Memorandum

To: City of Albuquerque Development Review Board

Date: September 13, 2019

Re: Comment Responses for PR-2018-001670

DESIGNED BY: J.L.	DRAWN BY: J.M.T.	CHECKED BY: SEG.	DATE: 9.25.2019
THIS DRAWING IS INCOMPLETE AND NOT TO BE USED FOR CONSTRUCTION UNLESS IT IS STAMPED, SIGNED AND DATED.			
PROJECT NAME:		UHAUL 4TH ST & I-40	
SHEET TITLE:		CONCEPTUAL UTILITY PLAN	
SUBMITTED FOR:		REVIEW	
SHEET NUMBER:		C 101

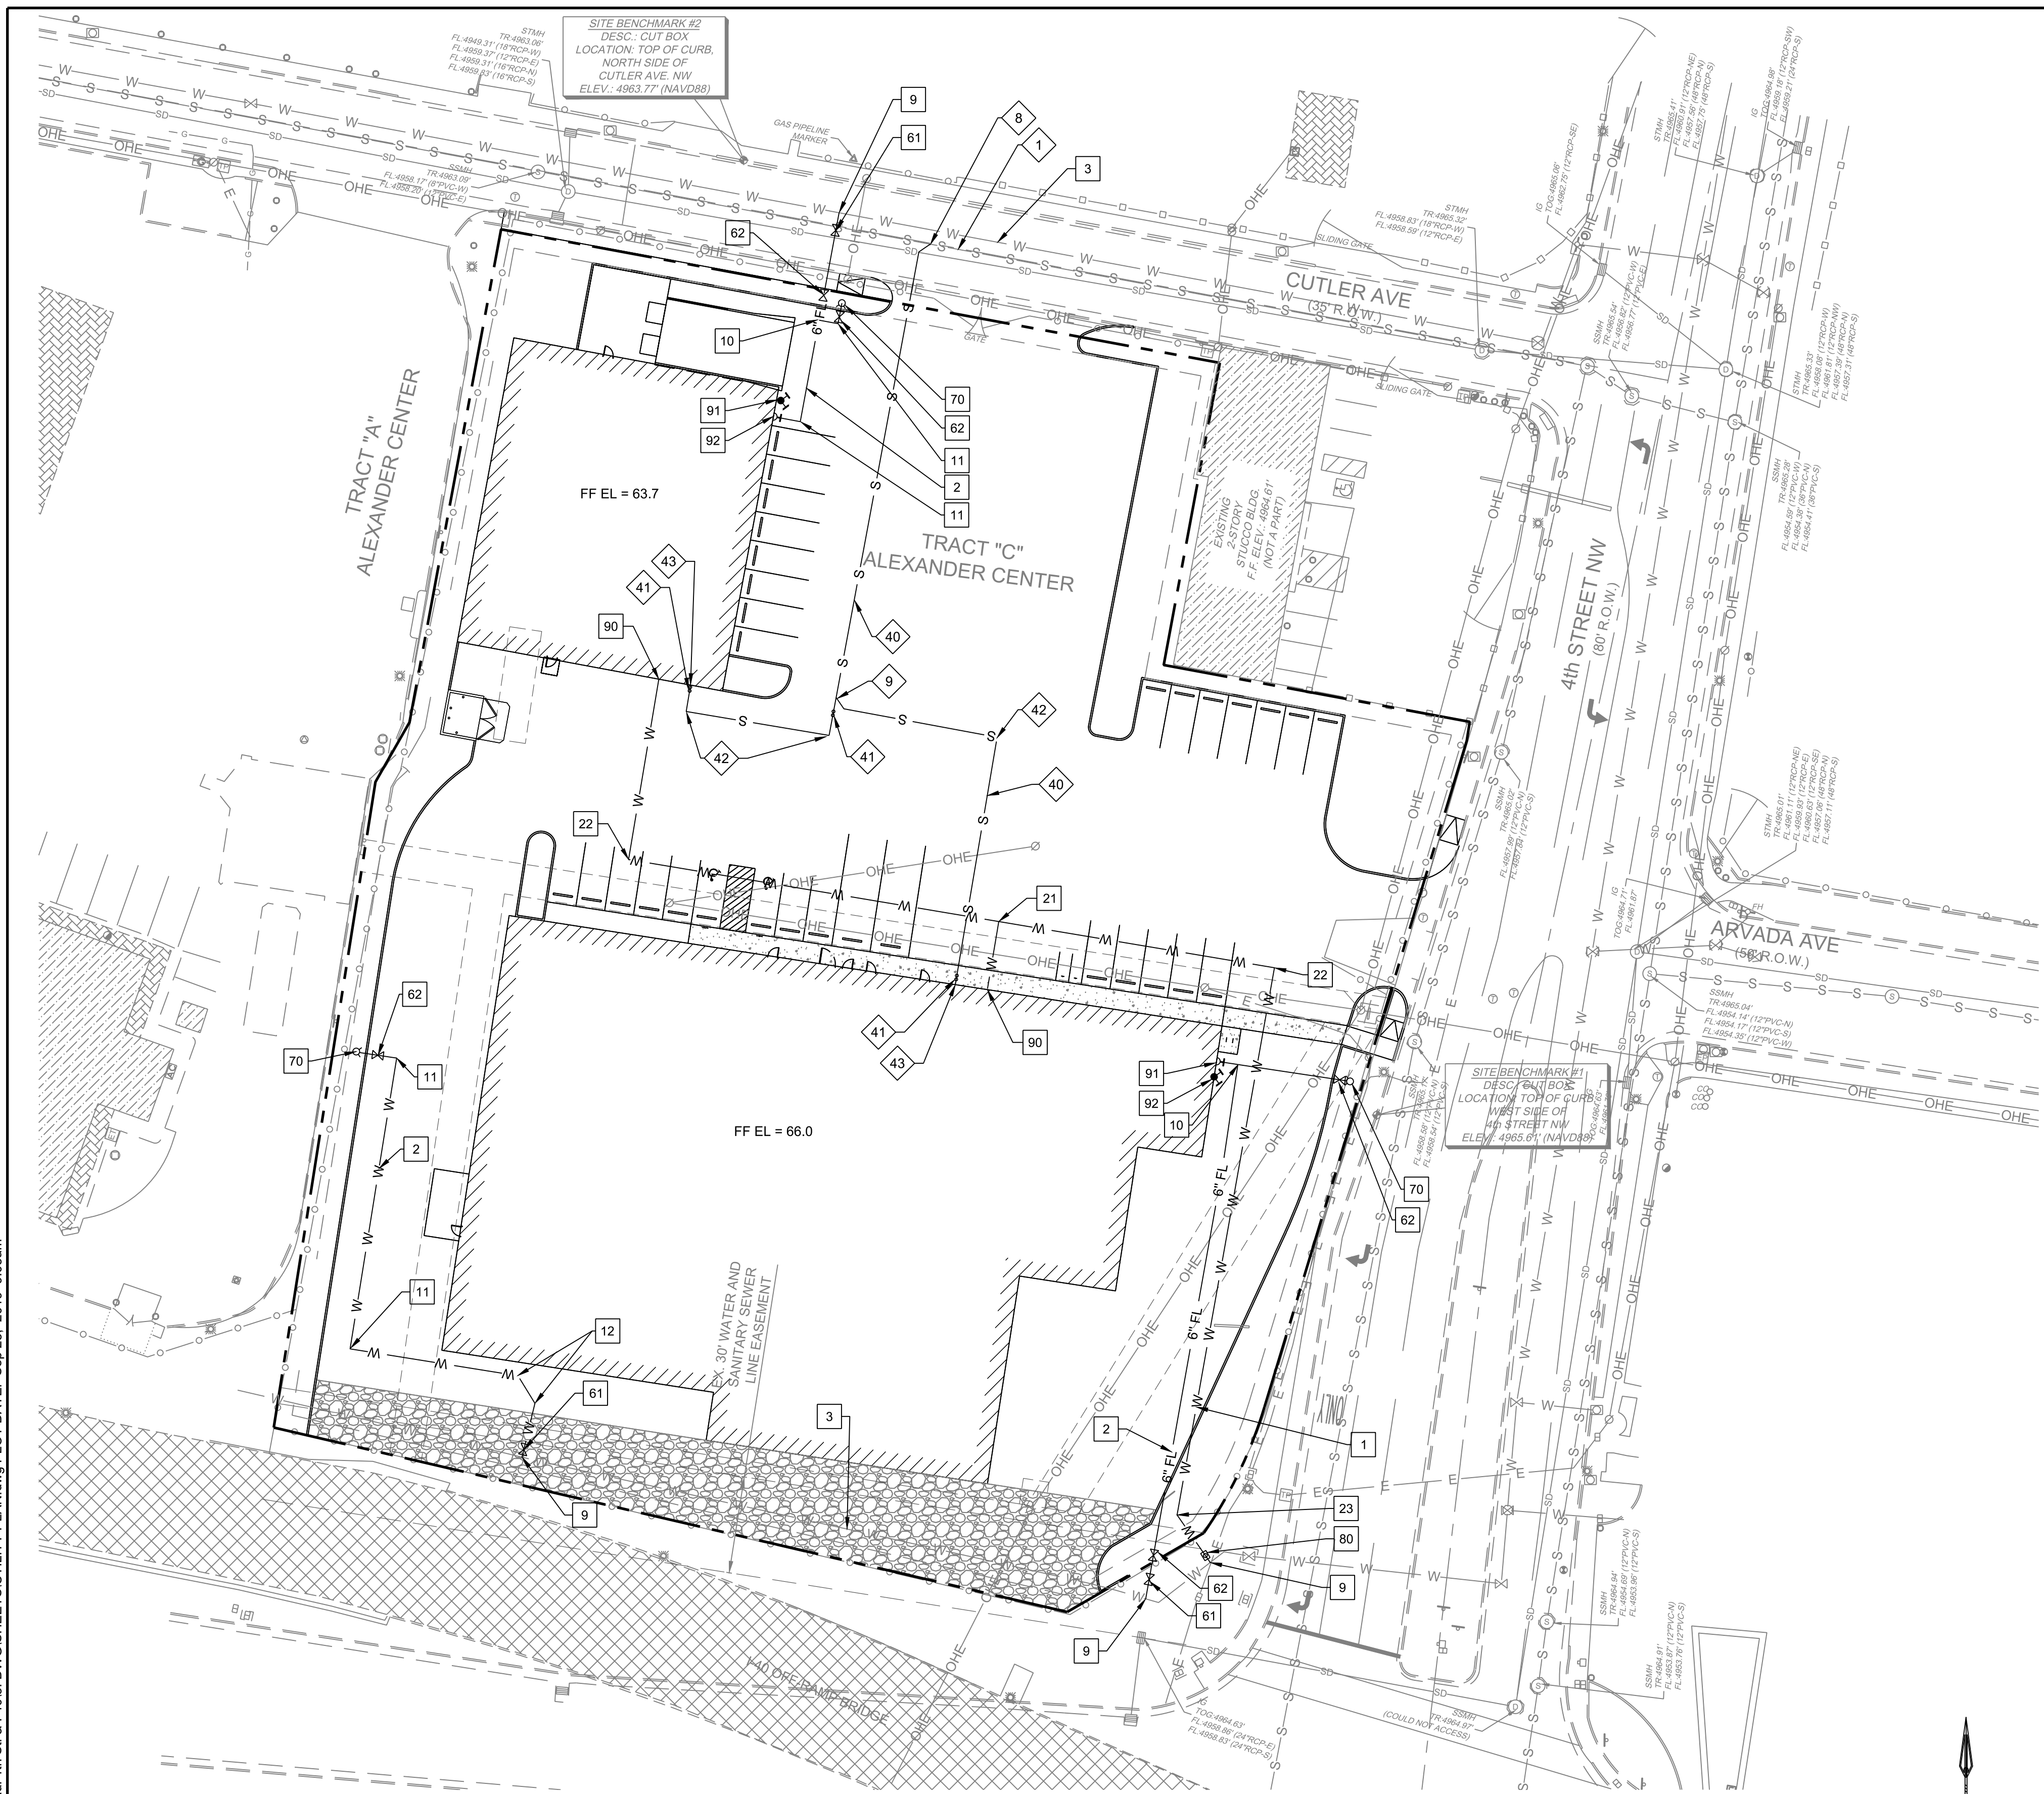
1. A utility plan was not provided with the submittal.
 - a. *Revised utility plan attached.*
2. Availability statement #190607 has been issued and provides the conditions for service.
 - a. *Noted.*
3. Records indicate there is an existing 8" sanitary sewer along the east property line on the property. Please coordinate with 811 to determine its location and ensure there are no proposed encroachments. Proposed utility plan indicates connection to an existing 12" sanitary sewer along 4th St. in which there are no records of.
4. Indicate all onsite fire hydrants are private.
 - a. *Note added to utility plan that onsite hydrants to be private and painted safety orange.*

7 U-STYLE BIKE RACK NTS

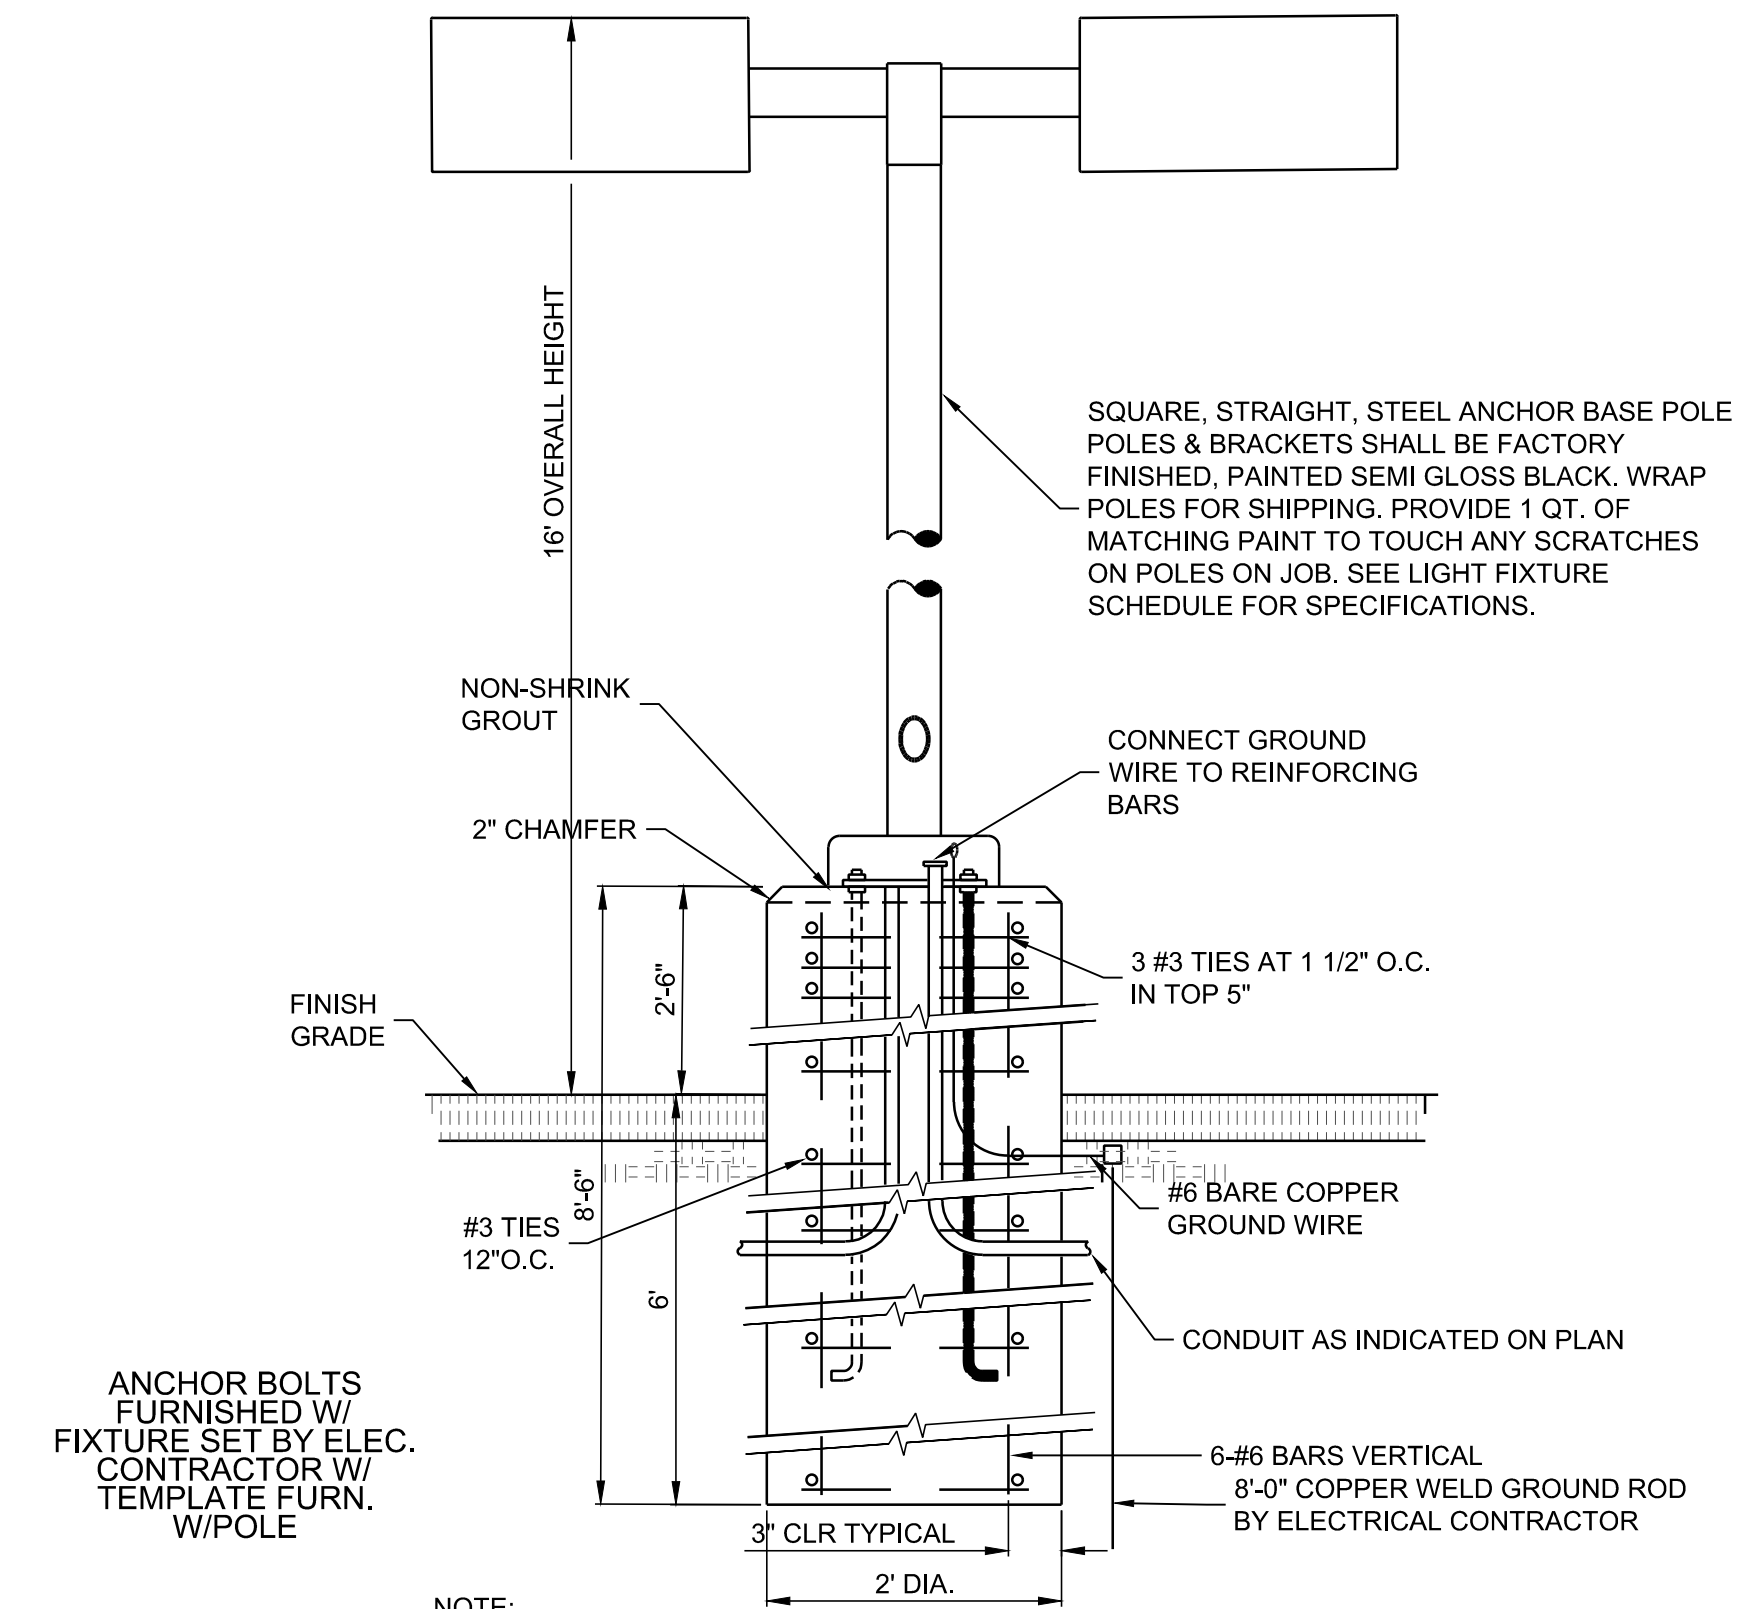
3. Bike Rack needs to meet criteria below
5-5(E)(4)(d) Racks shall be designed to support the bicycle in an upright position and so that both wheels and 2 points of the frame may be locked securely to it using a U-shaped lock or a chain/cable and lock.

- a. *The bike rack detail has been changed to a U-style rack to meet this requirement and location moved to not interfere with ADA access on walkway.*
